From: Nicola and Stephen Harlow, 25 Upper Drive, East Preston

Planning Application EP/7/21/HH

Objection and comments relating to proposed front extension to provide additional garaging

Drawing Name
Floor Plans and Roof Plan - Proposed

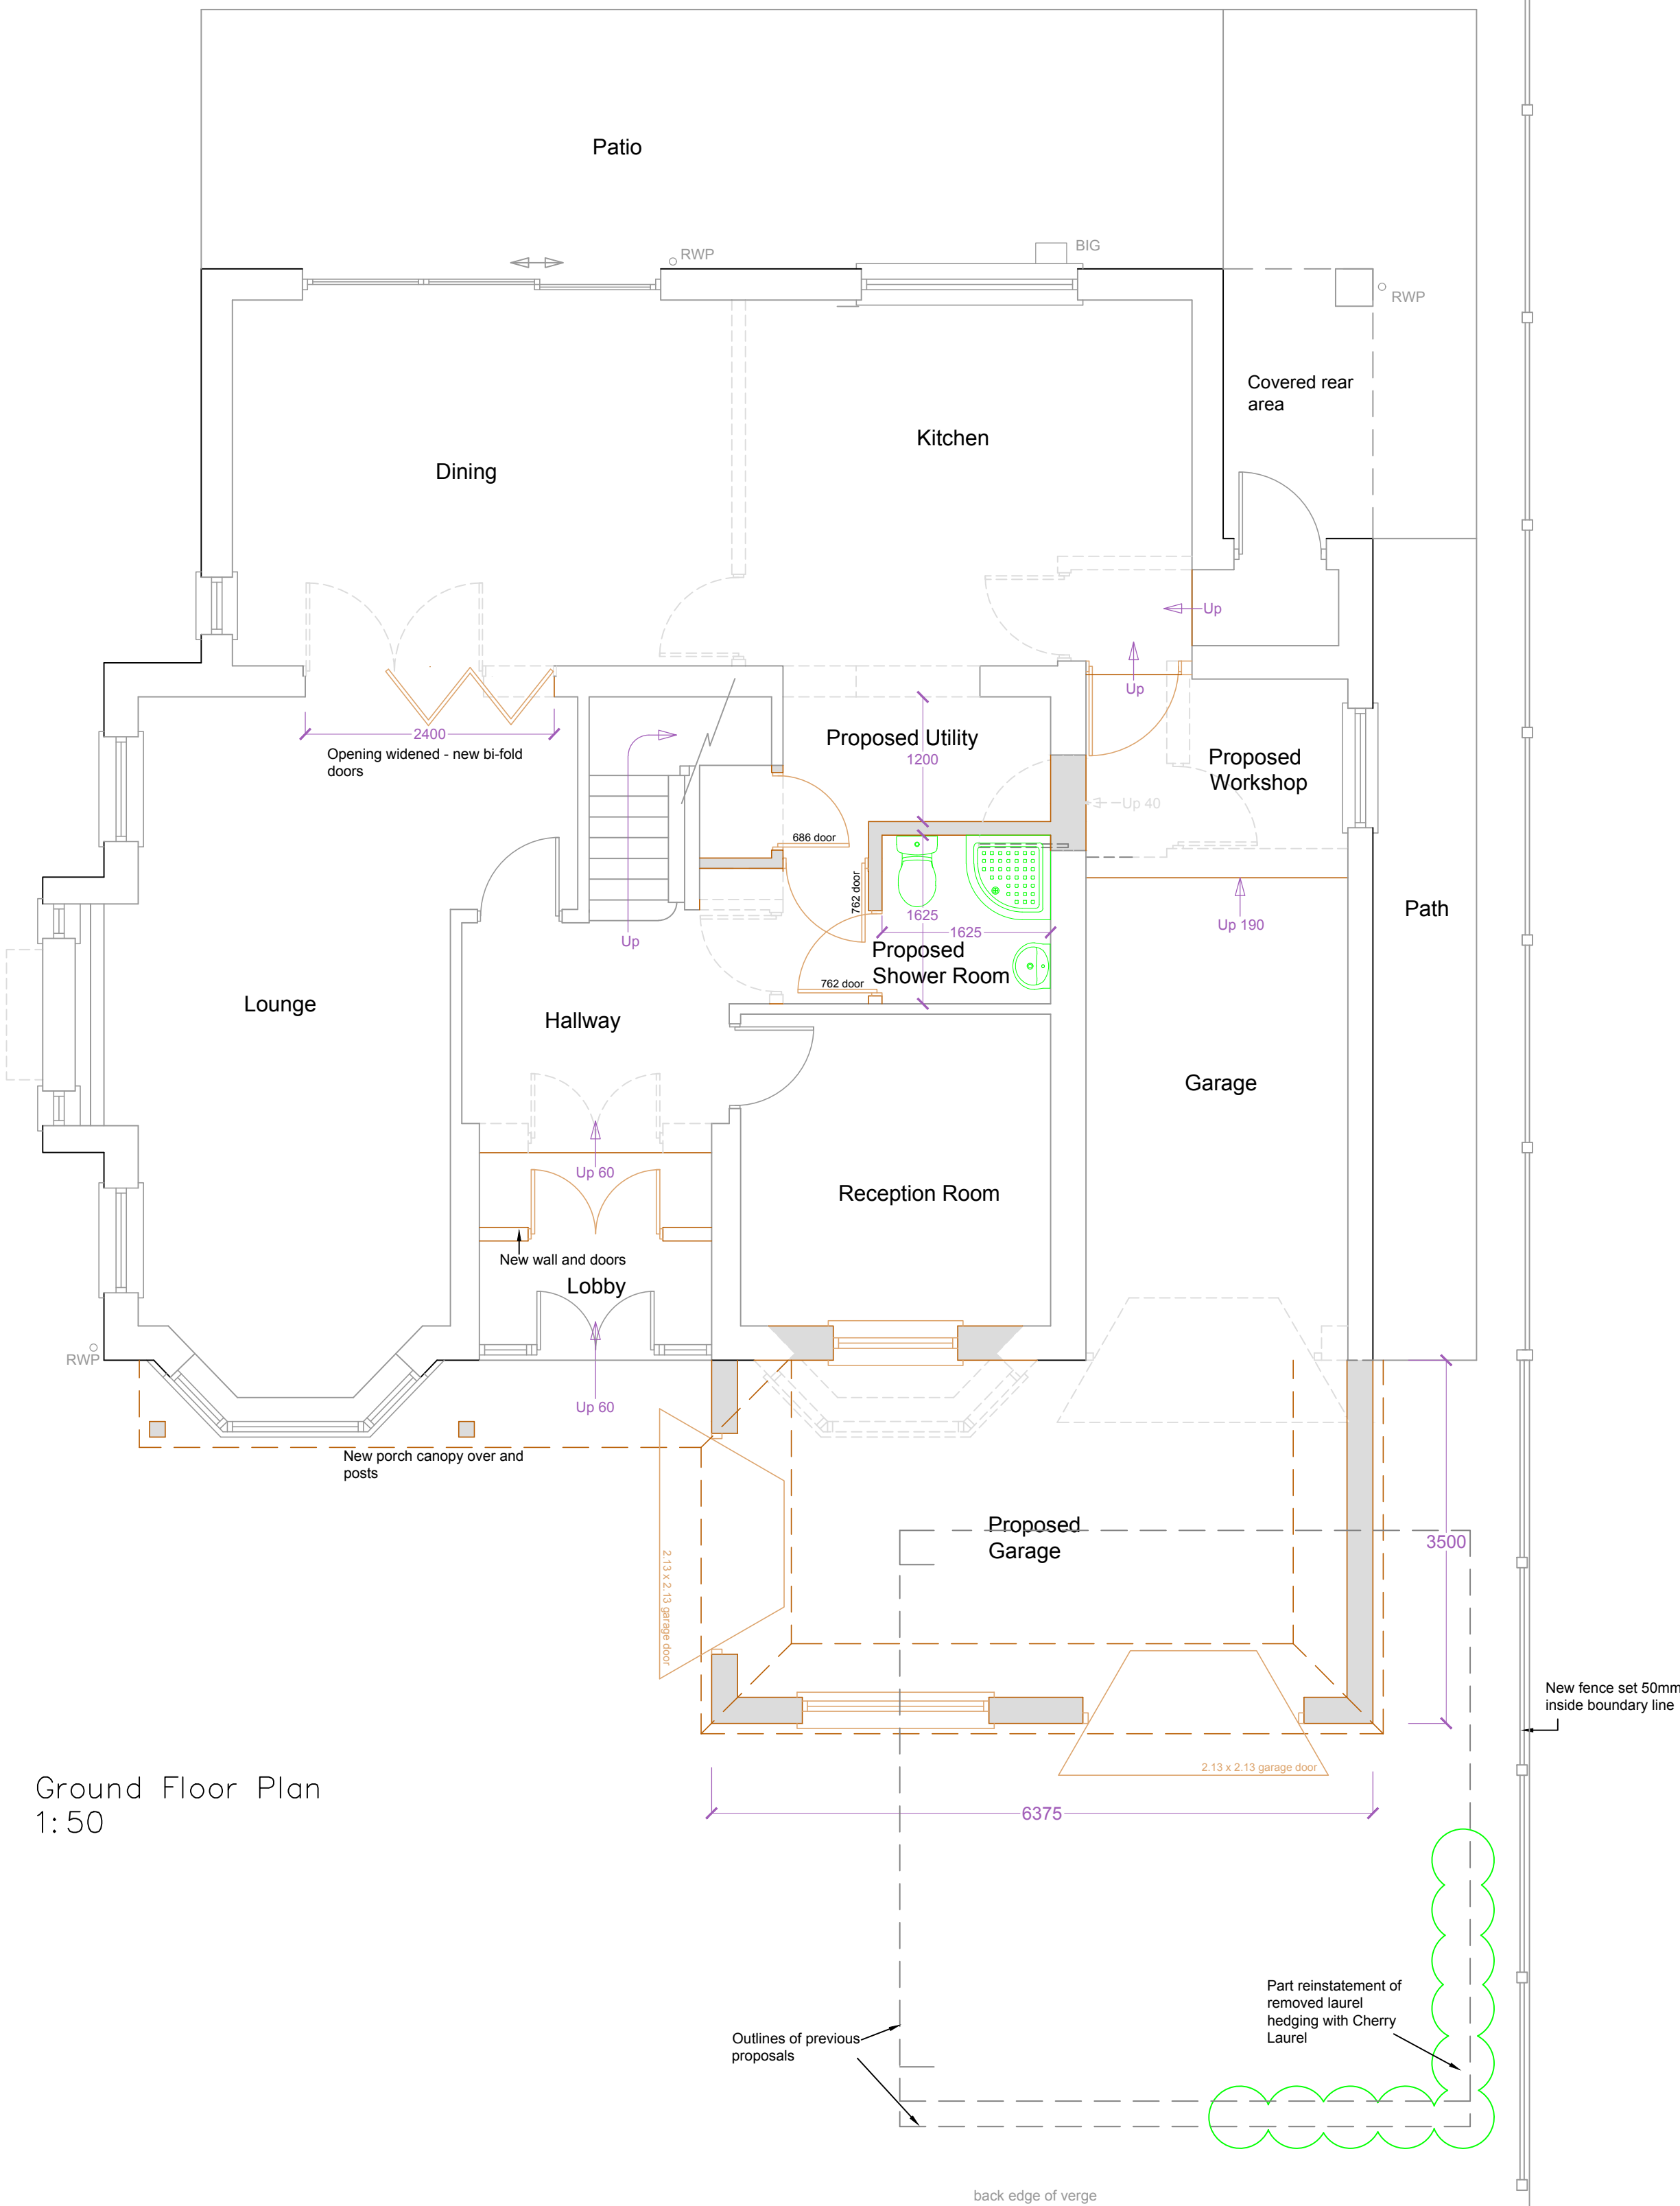
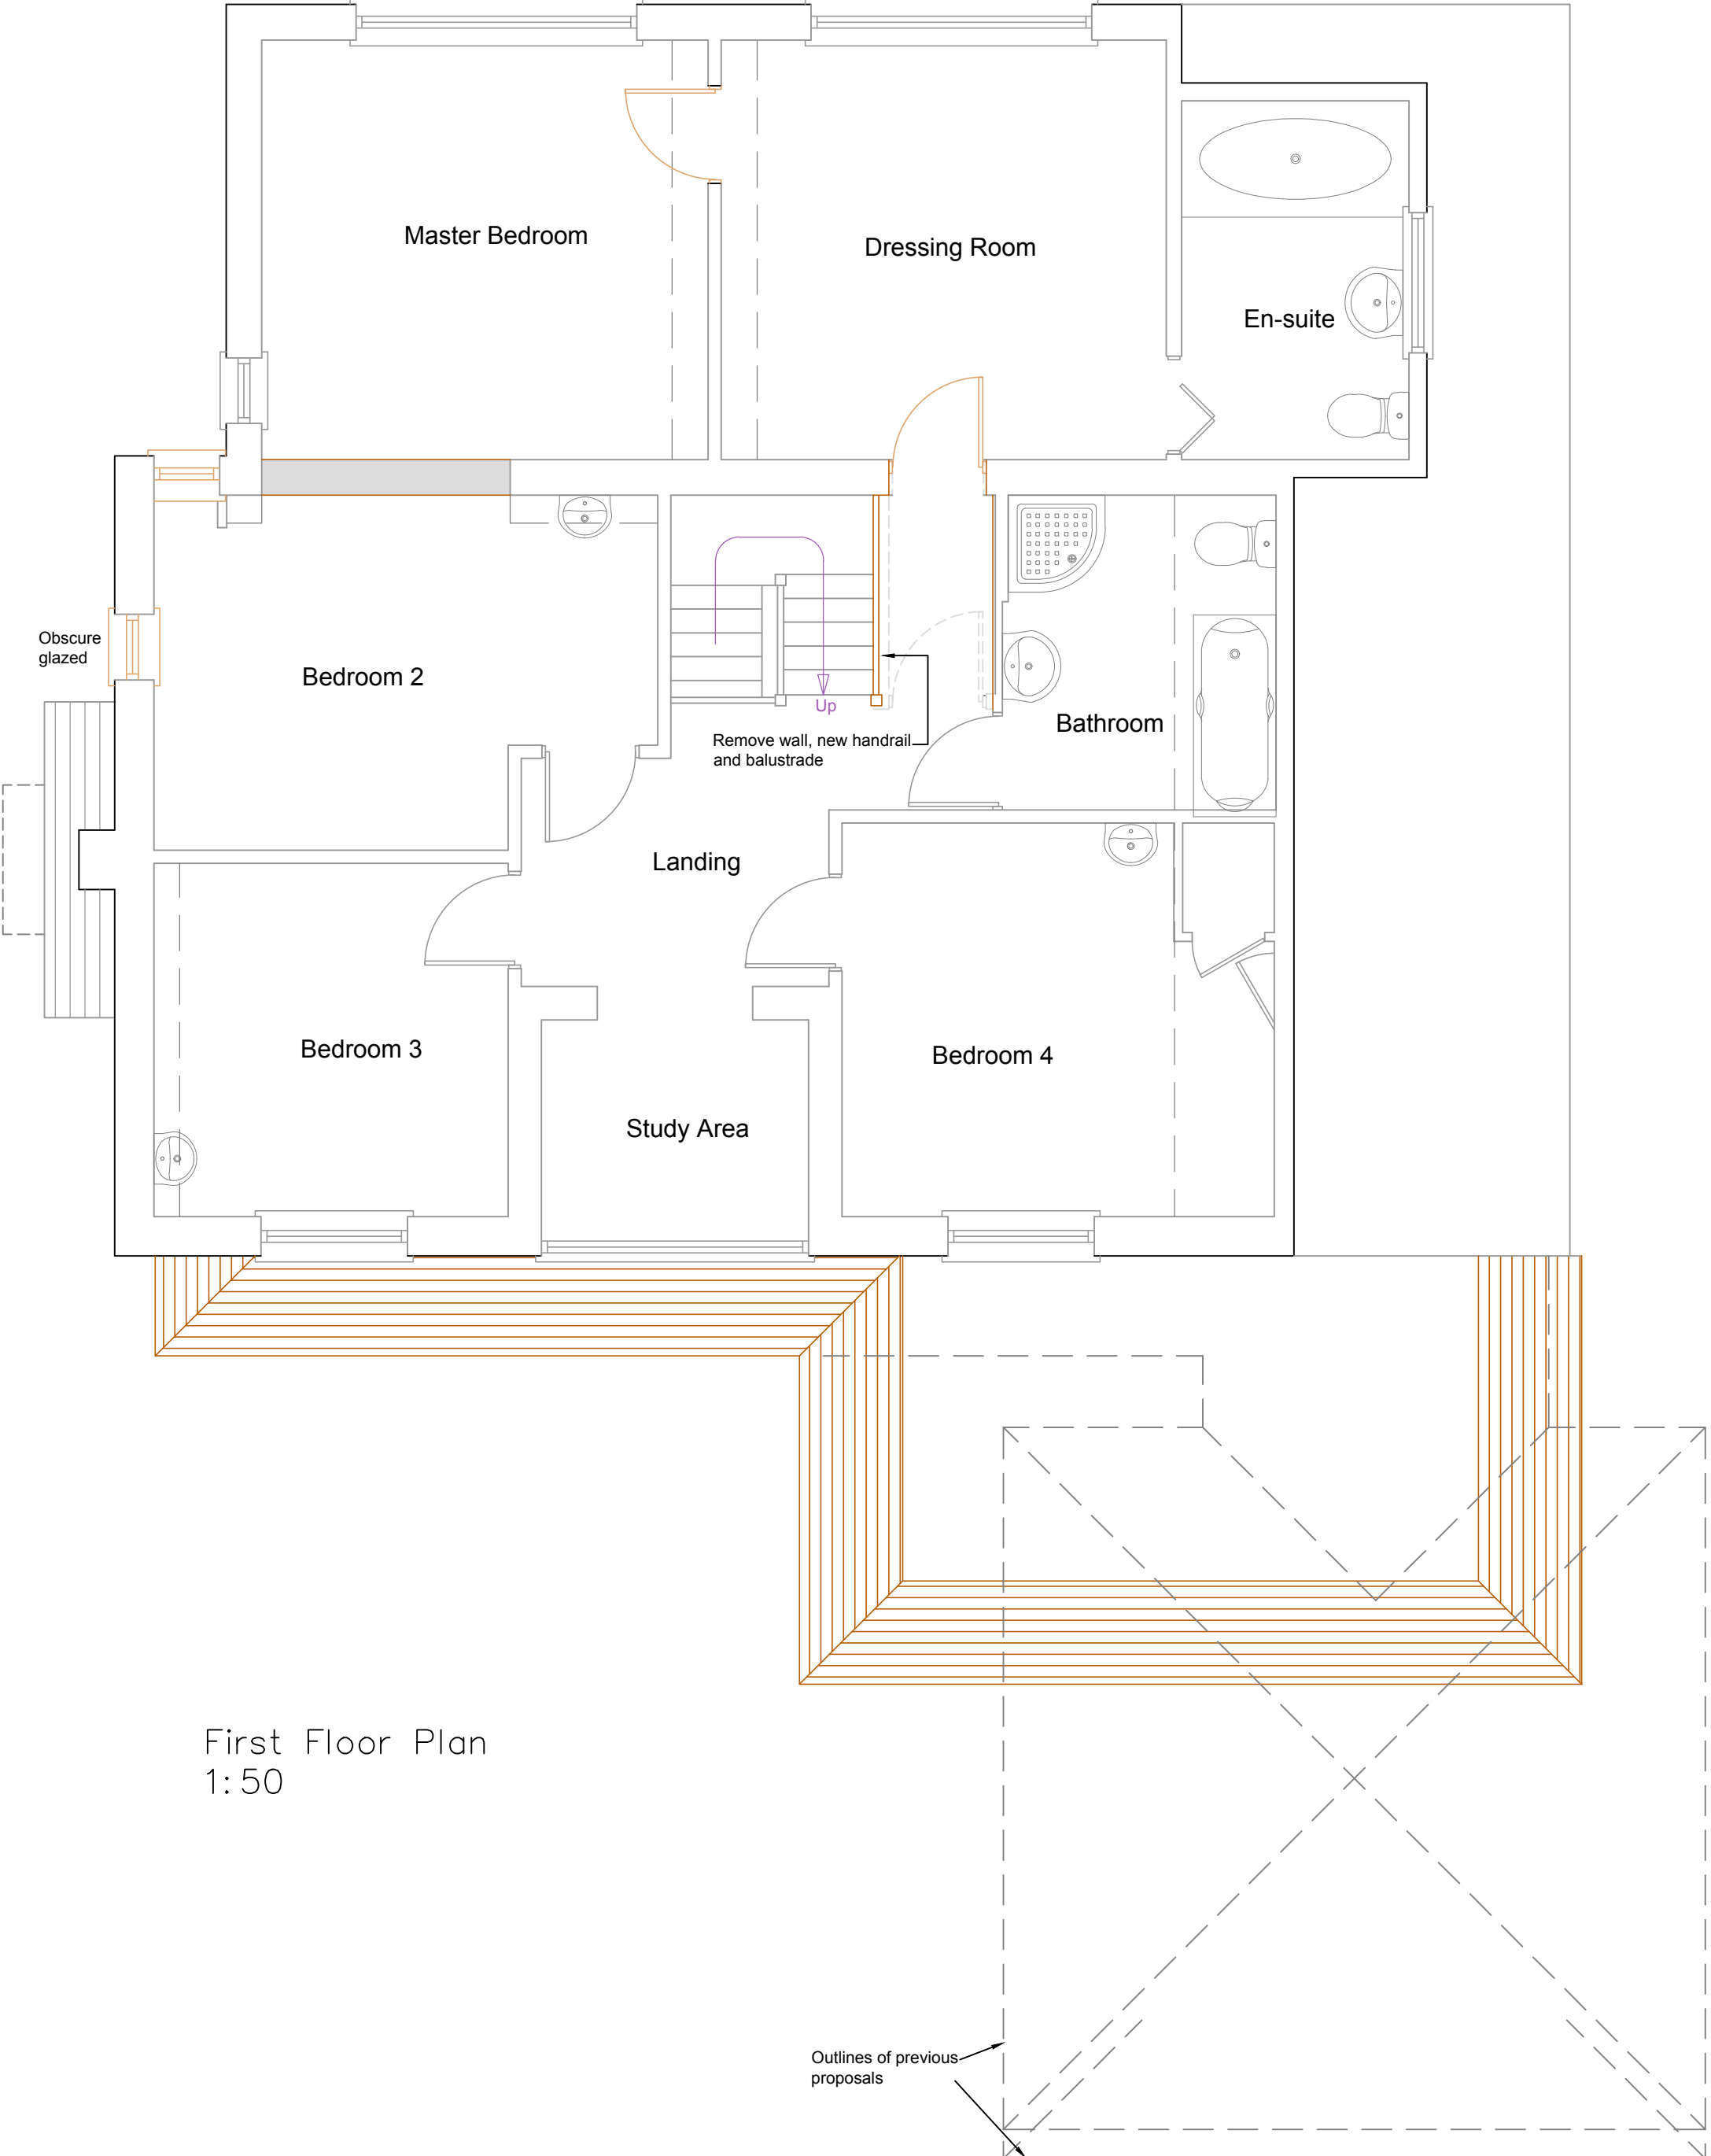
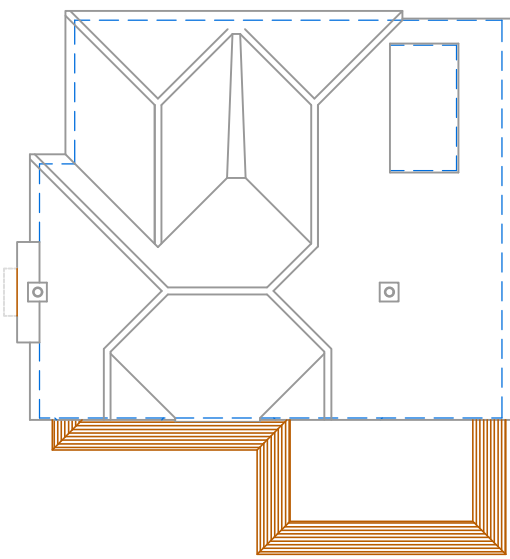
The proposed garage is 3.5 metres deep.

The proposed garage will take away natural light to the reception room on the north side of 23 Upper Drive. This will affect both current occupants and future occupants.

The drawings show that the proposed garage meets the 45 degree rule in relation to the ground floor room at 25 Upper Drive but do not show the affect on the outlook from the first floor room (bedroom). The first floor is set back by 1.5 metres from the ground floor. It is not possible to tell from the drawings whether the 45 degree rule to protect the outlook from the first floor bedroom on the south east side of 25 Upper Drive is met.

The first floor bedroom on the south east corner of 25 Upper Drive will overlook the proposed garage. The plans do not show the design or material to be used for the flat roof of the proposed garage.

In order to ensure compliance with the Design Guide details of the materials to be used for the flat roof should be submitted.
